**From:**  
**To:** [DCAdmin](#)  
**Subject:** Planning Application 2020/62/93954/W Lingards Road  
**Date:** 30 November 2022 18:41:26

Project HOUSING AT LINGARDS RD SLAITWAITE
 Client SB HOMES LTD
 Drawing SITE SECTIONS ACROSS LINGARDS RD
 Scale 1:200
 Dwg No 2019 572 61

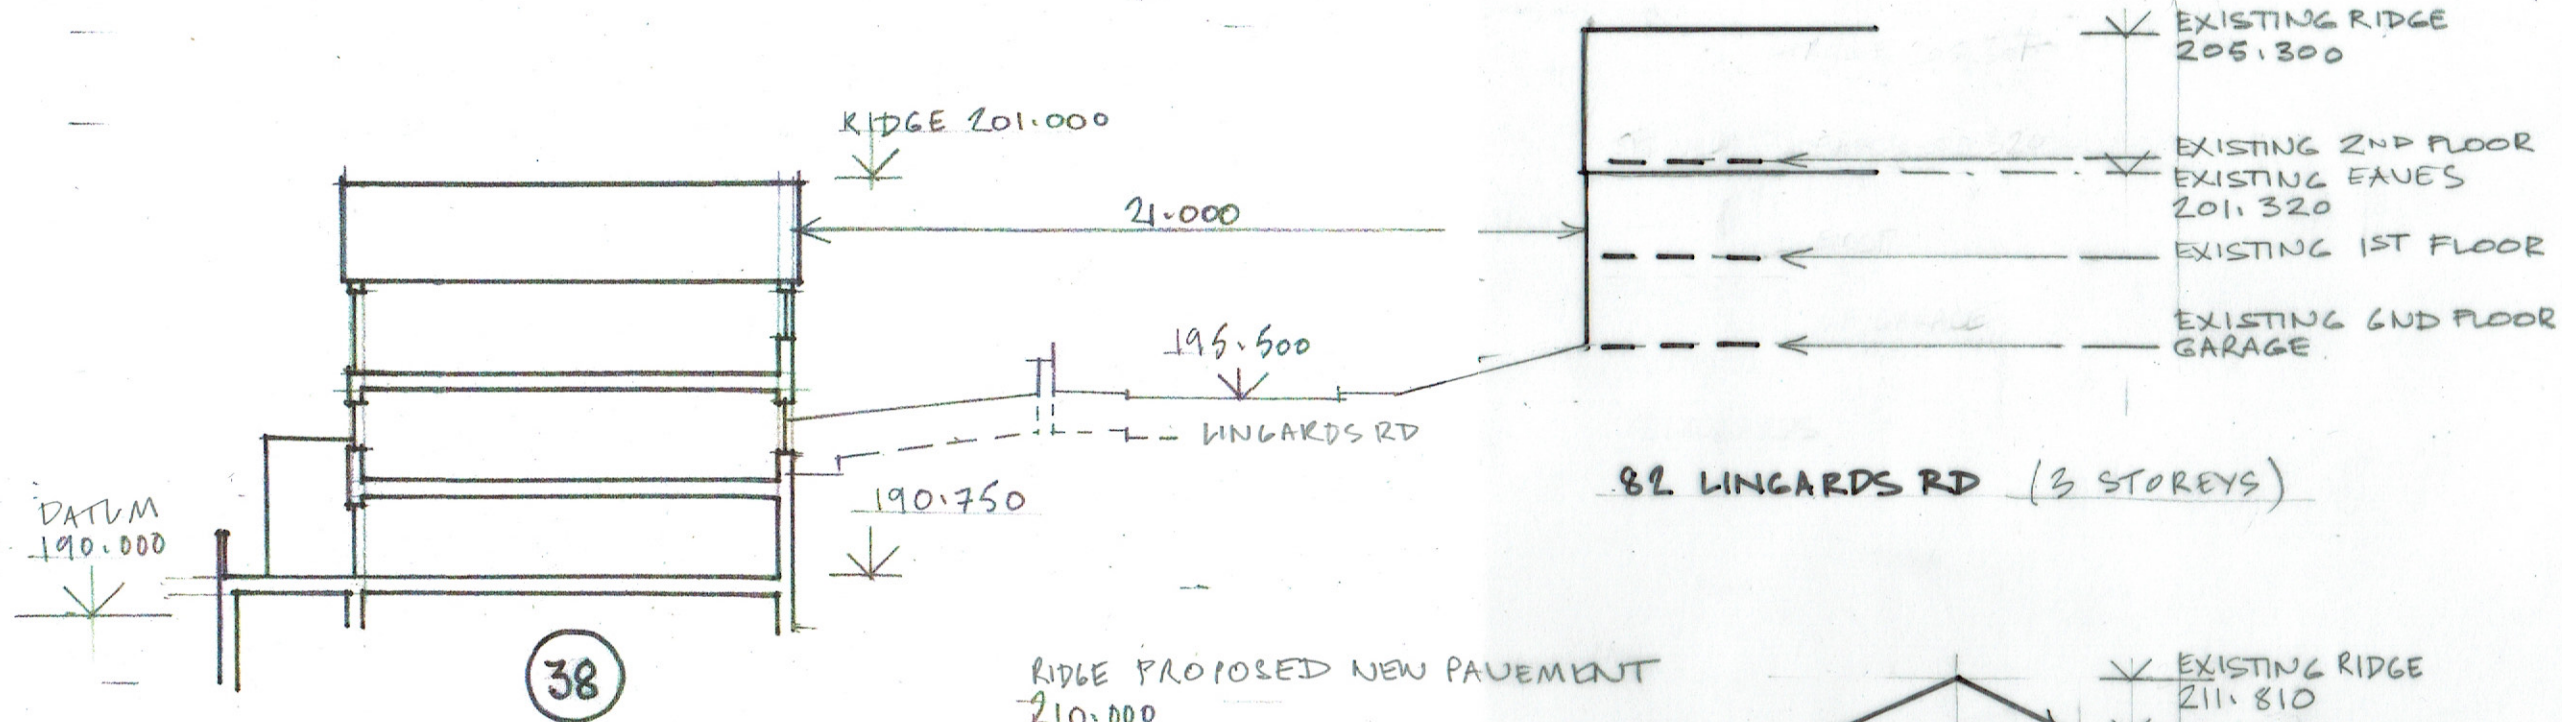
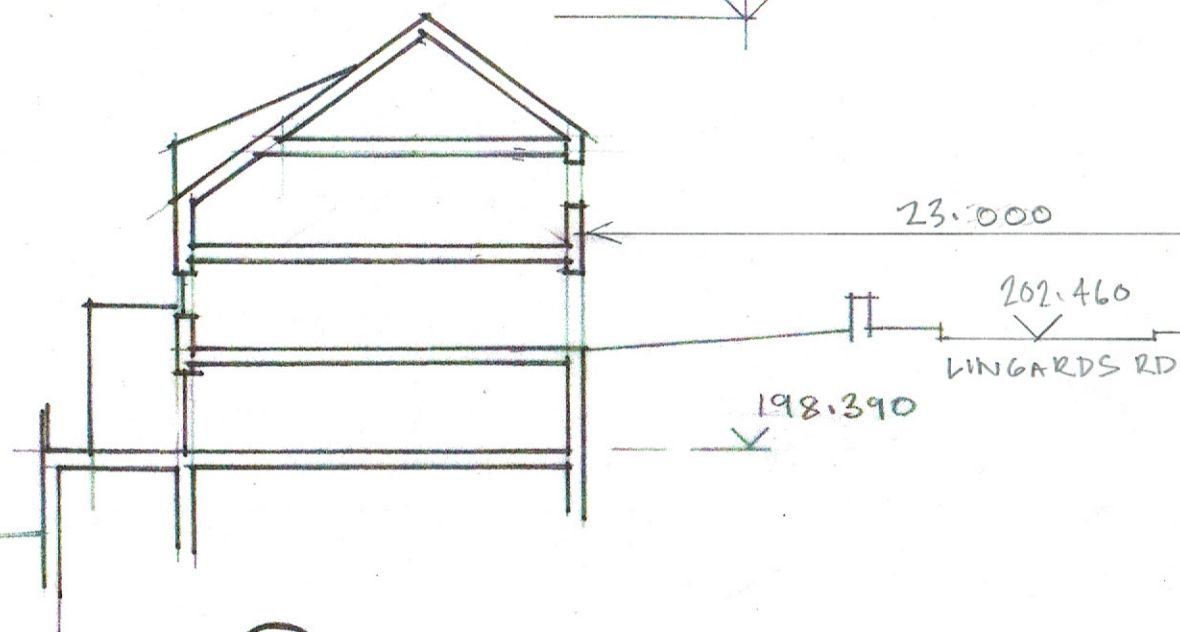
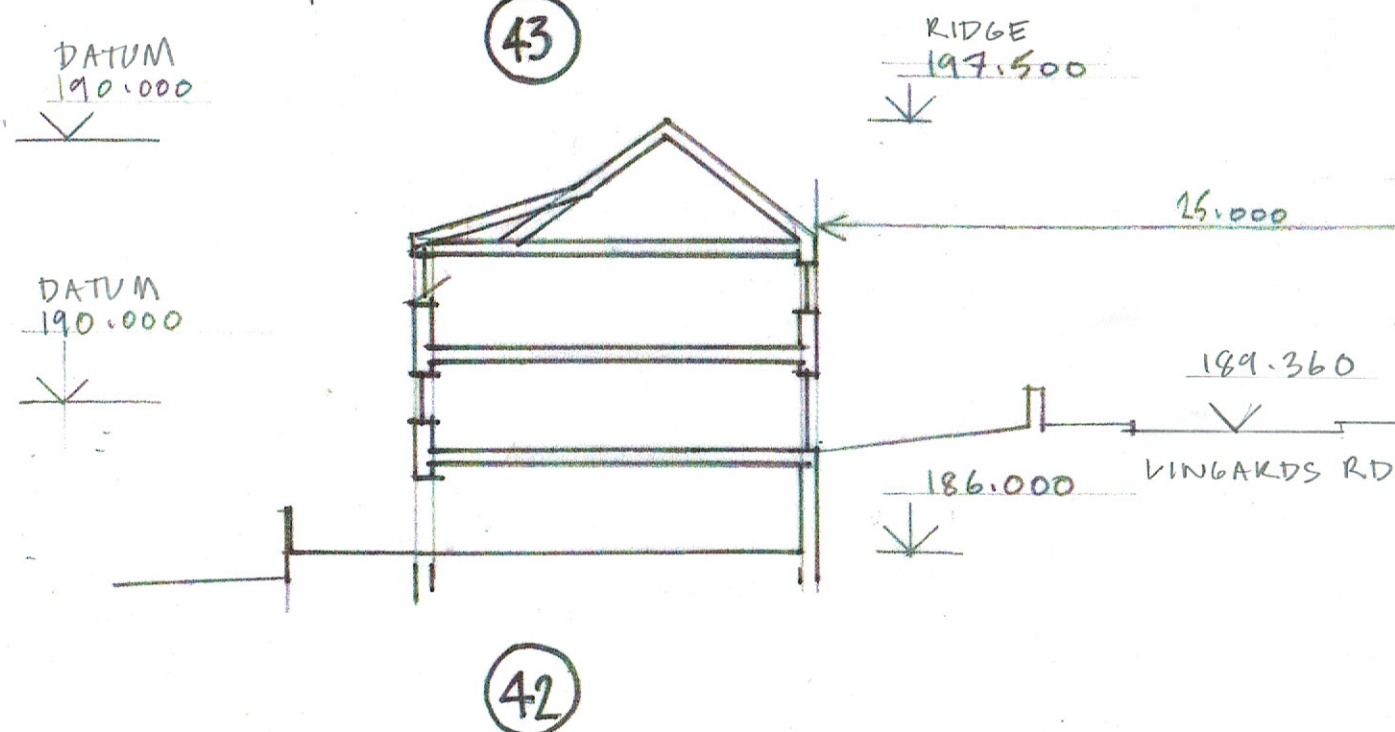
I also note that on the 23/11/2022 the Designers response to concerns / comments was posted. Under paragraph 2 addressing urban design and 3 storey houses we are instructed to "Refer to Section Drawing 2019 572 61 A which shows the relationship between the houses along Lingards Road with the development site" a drawing that contains a note "Existing floor levels are based on known ridge and eaves levels and photographic evidence and are approximate". Although I have not had the time yet to consider the new drawings fully, I noted this "approximation" in my previous comments and the designer is still using approximate measurements to demonstrate that the height of the 3 storey houses are acceptable.
